Application No: K/22/22/PL
Site Address: Land East Of Kingston House Kingston Lane Kingston BN16 1RP
Description of works: 3 No stables and a barn. This site is in CIL Zone 3 (Zero Rated) as other development.

I write as Chairman of the East Preston and Kingston Preservation Society to object to this application. While horse related activities are acceptable in this area, this particular application raises issues of concern.

STABLES

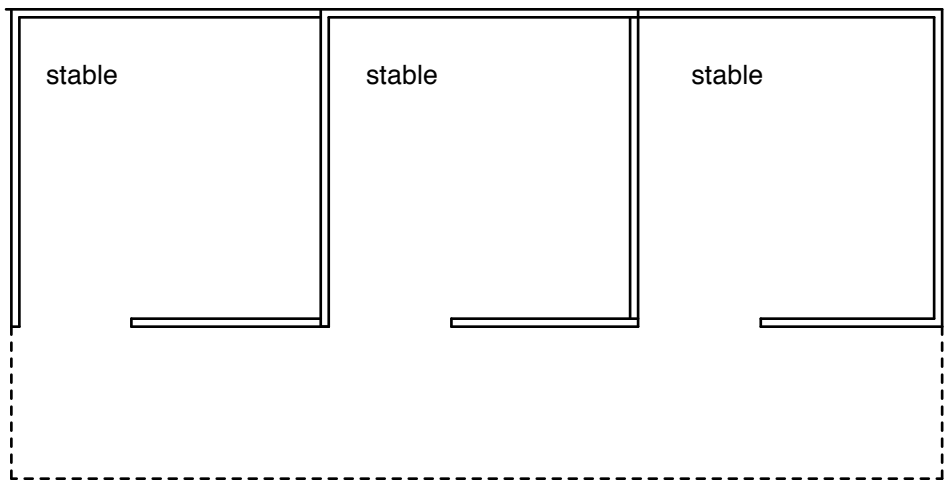
It is also concerning that the proposed hard standing is impermeable, if by "conc finish" is meant concrete, especially as the location plan shows a drain running along the western boundary of this site. Any impermeable surface might also lead to irreversible loss of Grade 1 or 2 agricultural land in contravention of KNP Policy 6 C ii.

THE NEW STABLES, KINGSTON, EAST PRESTON, WEST SUSSEX, BN16 1RP	
Client	Description
PROPOSED PLANS, ELEVATIONS & SECTIONS FOR STABLES & BARN

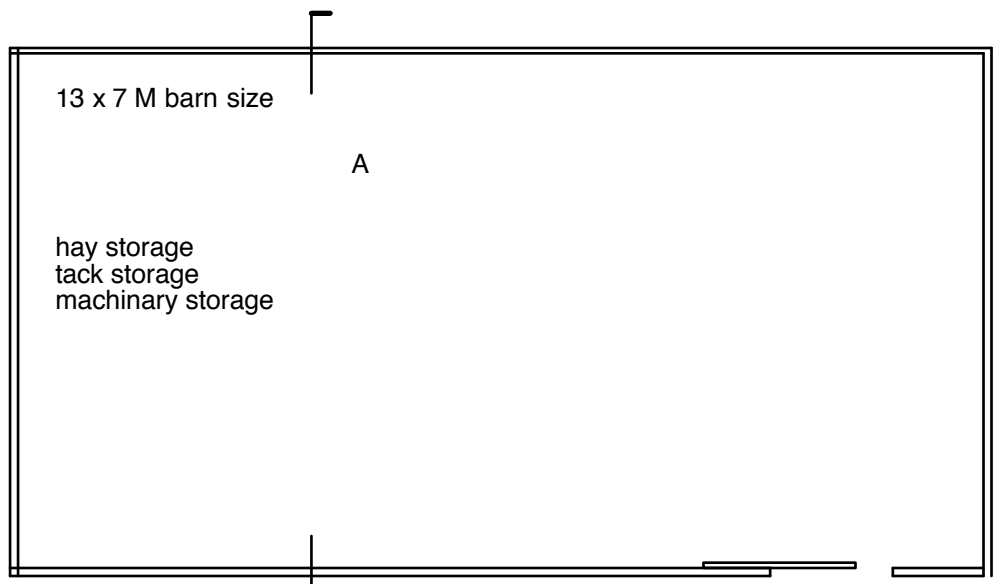
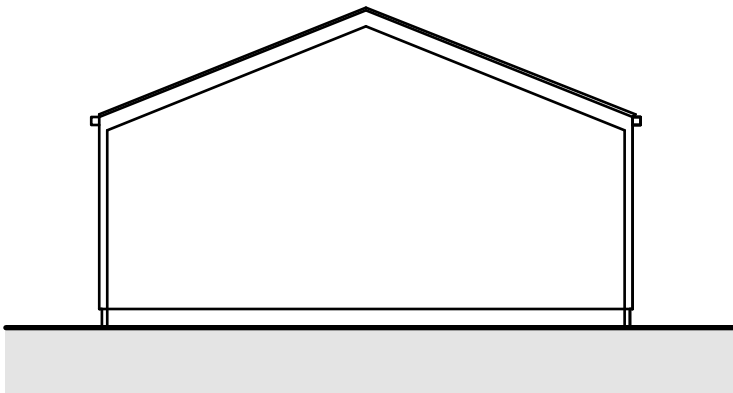
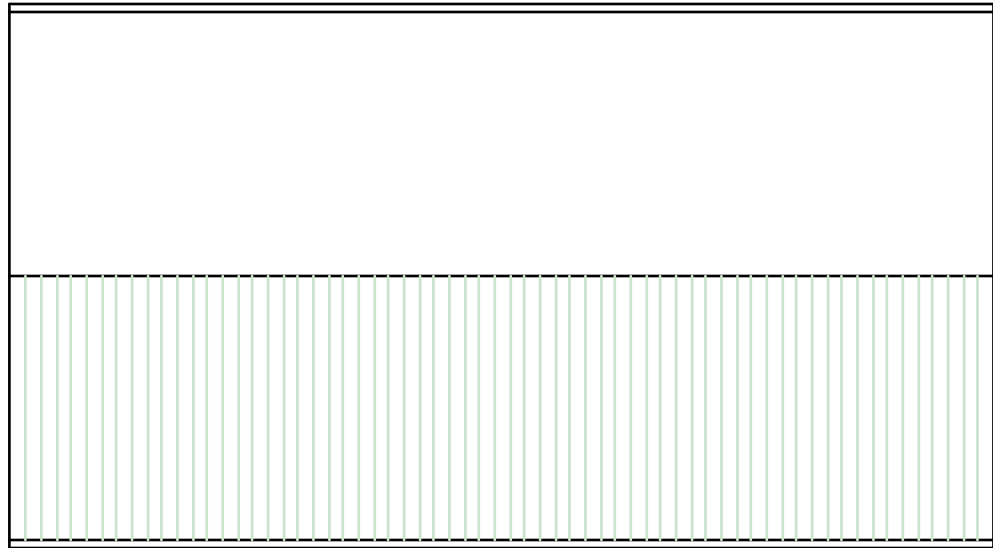
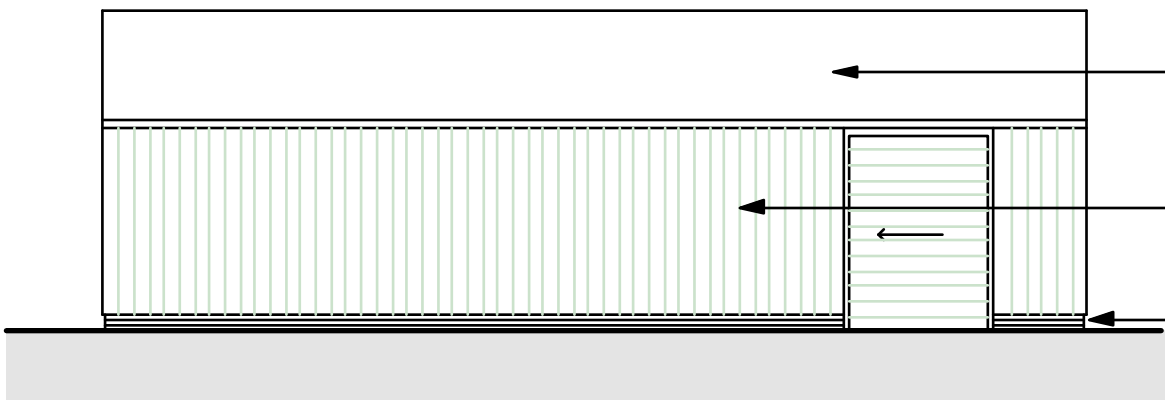
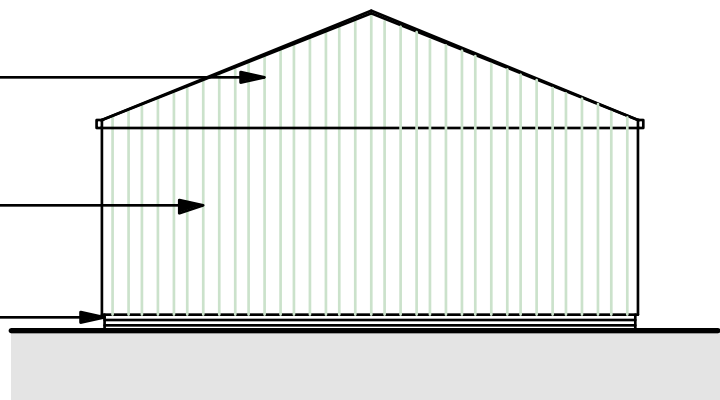
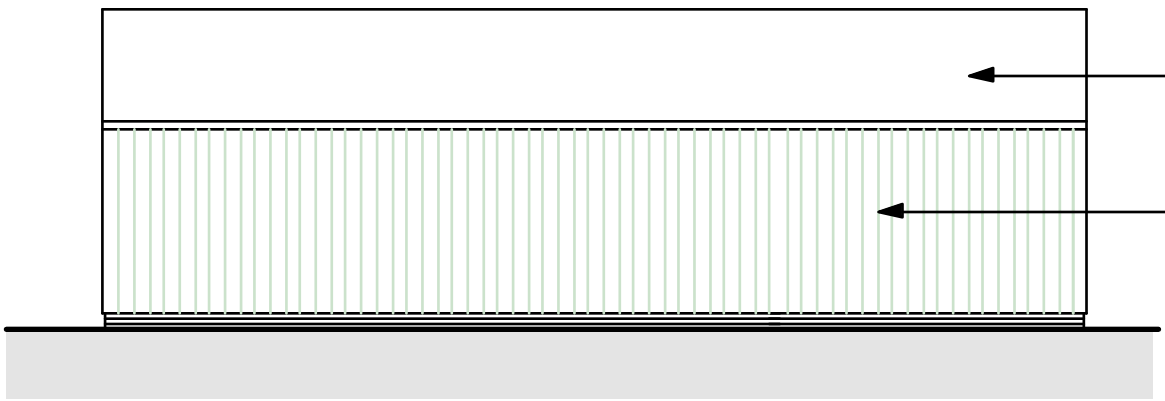
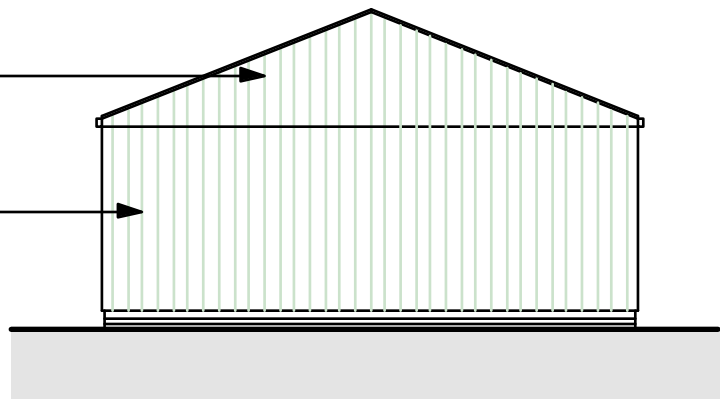
The stable buildings planned in the present application are not objectionable, being of suitable scale, position and materials to blend in to this open landscape. The same cannot be said for the proposed barn building, which at at least 4m tall and constructed using green metal cladding, would be unacceptably obtrusive, and detract from the landscape quality of the area, thus contravening Kingston Neighbourhood Plan (KNP) Policy 6 C iii. In addition, the application for use class B8 has potential for uses which would erode the character of this Gap between Settlements.
